RE: ENGINEER'S CERTIFICATION FOR BRUNACINI WAREHOUSE, LOT 6, RICHFIELD PARK
(C17/D2A12) SUBMITTED FOR CERTIFICATE OF OCCUPANCY RELEASE,
ENGINEER'S STAMP DATED 11/14/95.

RE: ENGINEER'S CERTIFICATION FOR BRUNACINI WAREHOUSE, LOT 6, RICHFIELD PARK
(C17/D2A12) SUBMITTED FOR CERTIFICATE OF OCCUPANCY RELEASE

RE: GRADING AND DRAINAGE PLAN FOR BRUNACINI WAREHOUSE, LOT 6,
RICHFIELD PARK, (C17-D2A12), SUBMITTED FOR SITE DEVELOPMENT PLAN
AND BUILDING PERMIT, ENGINEER'S STAMP DATED 1/25/95.

RE: GRADING AND DRAINAGE PLAN FOR BRUNACINI WAREHOUSE, LOT 6,
RICHFIELD PARK, (C17-D2A12), SUBMITTED FOR SITE DEVELOPMENT PLAN
AND BUILDING PERMIT, ENGINEER'S STAMP DATED 1/9/95.

GRADING AND DRAINAGE PLAN

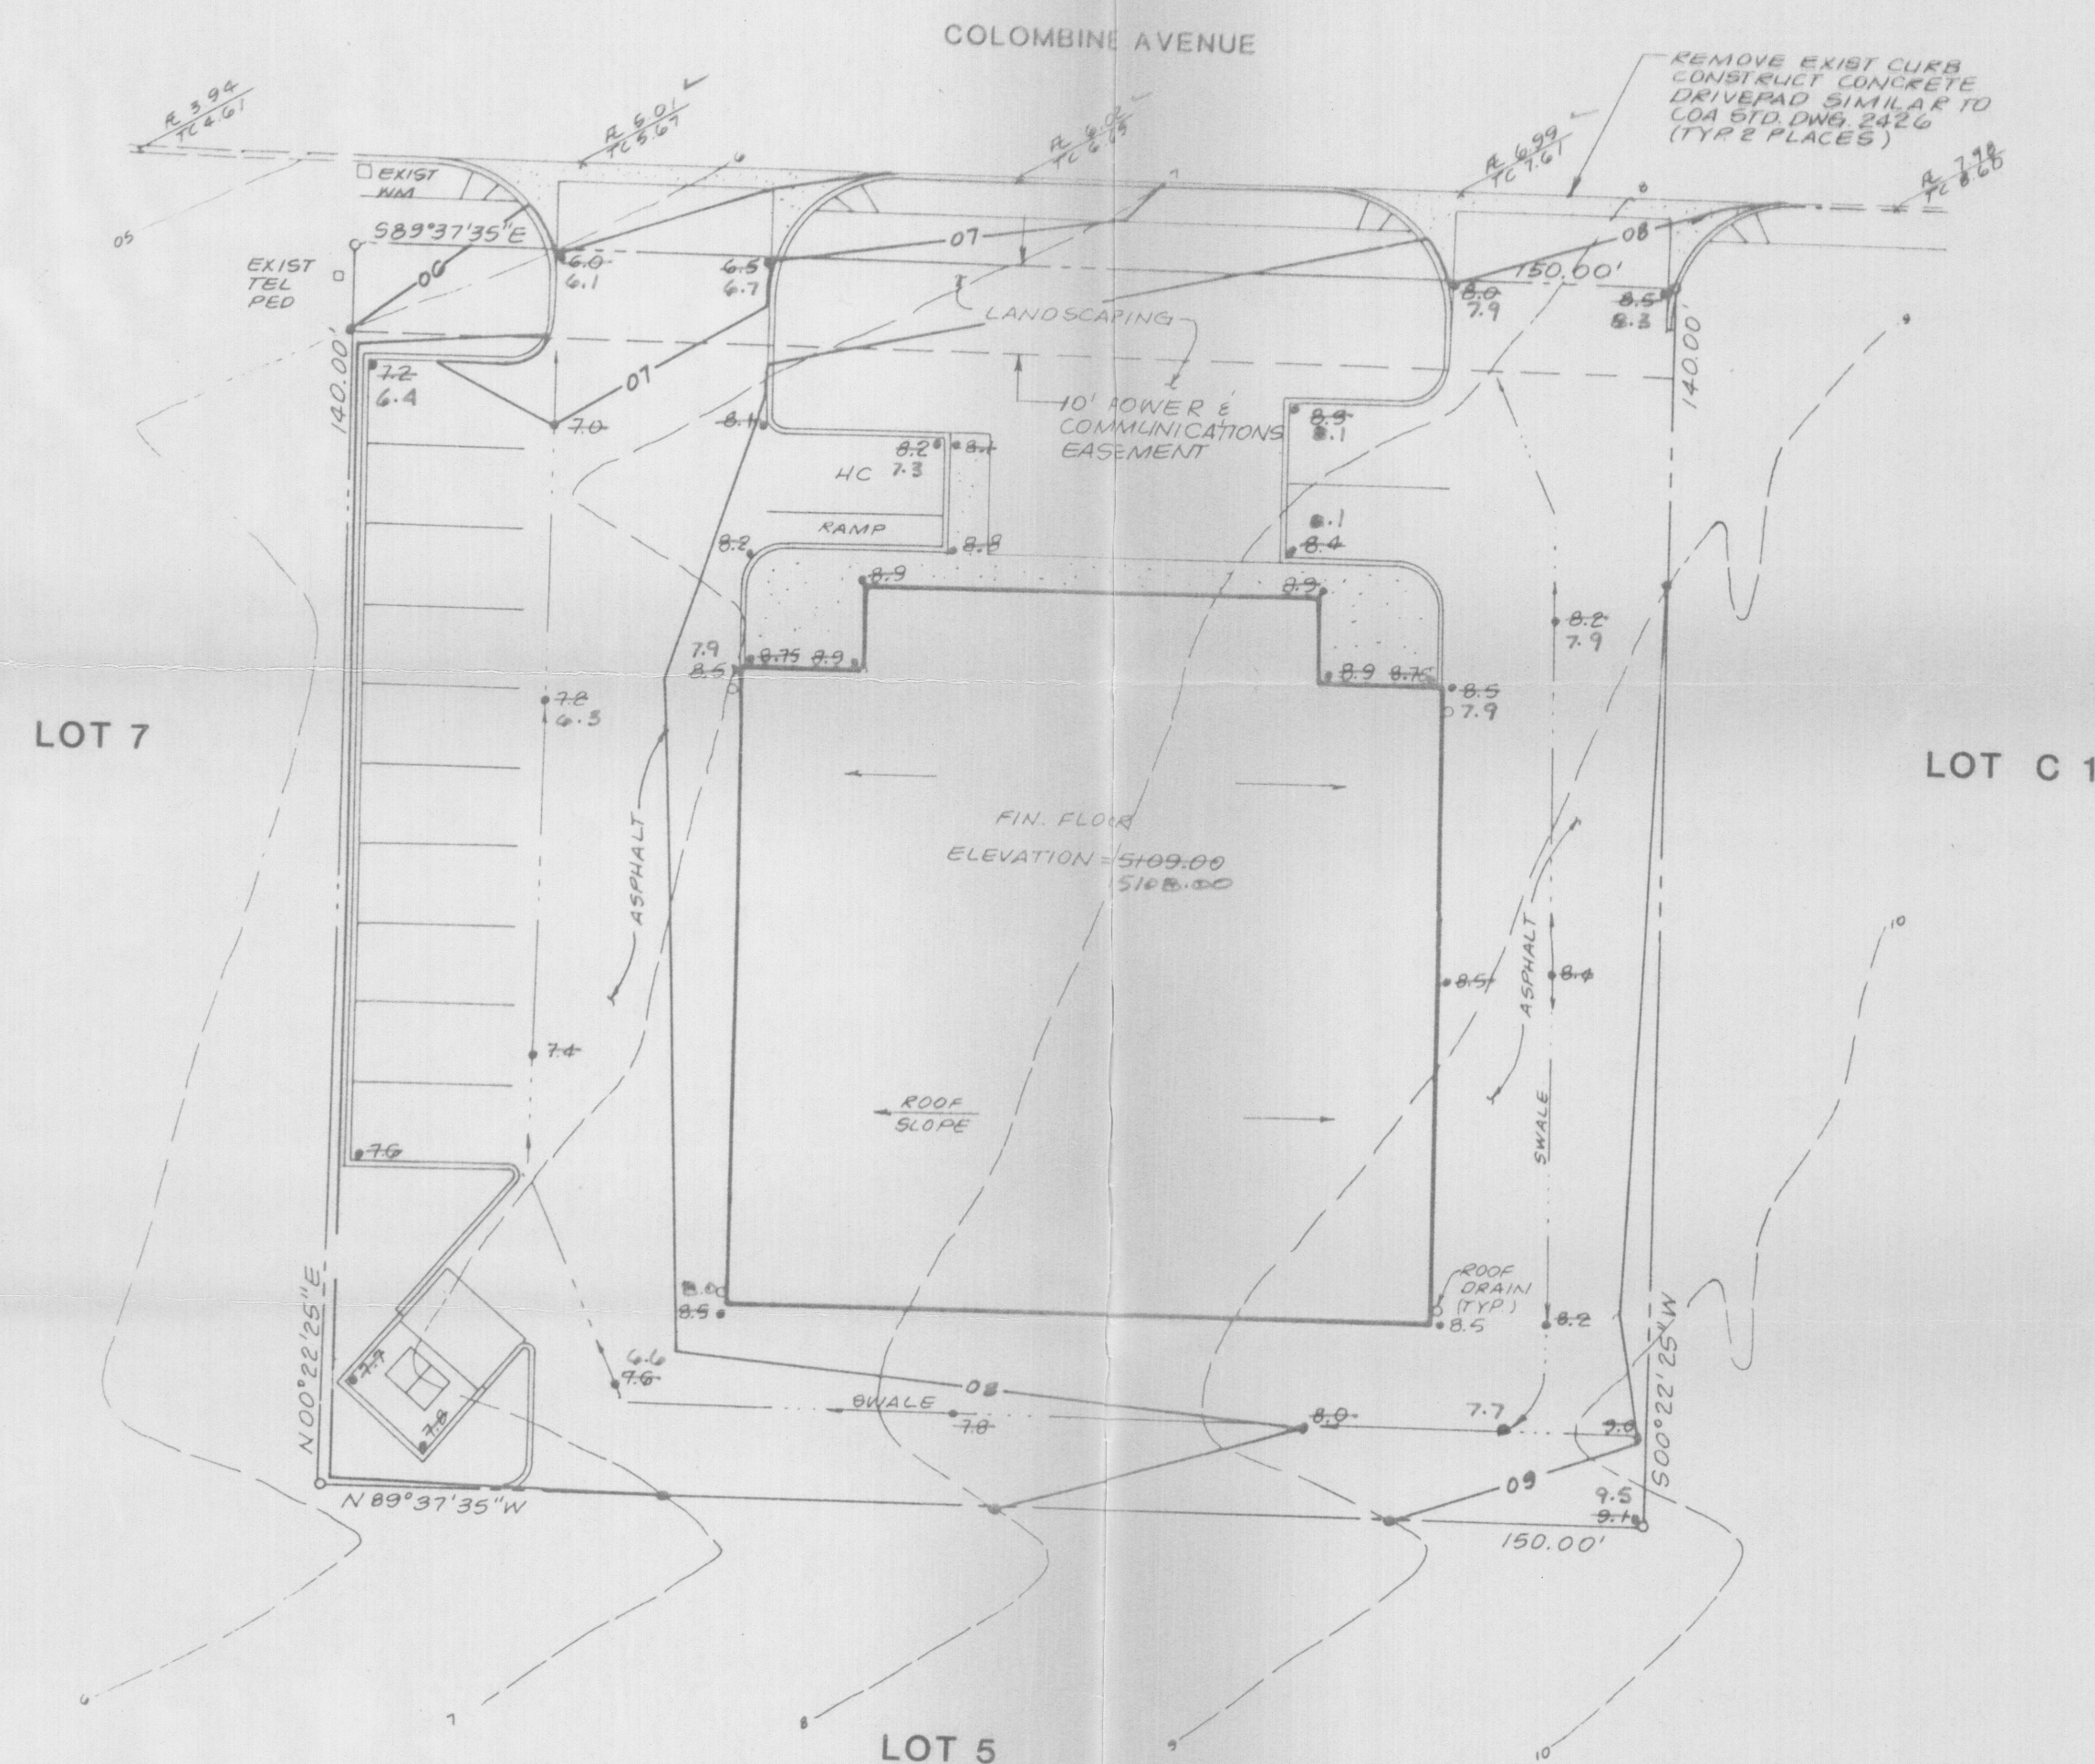
1. Although storm drainage improvements have been constructed in the area, this site remains in a designated flood hazard area according to FEMA. Please show the limits of the 100-year floodplain on the site plan and reference the FIRM panel number. Also delineate the lot on the FEMA map. A note should be added to the plan stating that a Letter of Map Revision has not been ~~obtained from FEMA and that the property owner may be subject to the flood insurance regulations established by the National Flood Insurance Program.~~

2. The plan mentions that a Master Plan has been approved for the subdivision. Please reference the Master plan. Was it prepared using new hydrology? ✓

3. It appears that off-site flows enter the site from the east side. Please delineate the off-site basin and calculate the off-site flows which impact this site. ✓

4. Please label the adjacent lots and identify any existing easements adjacent to the property, if any. ✓
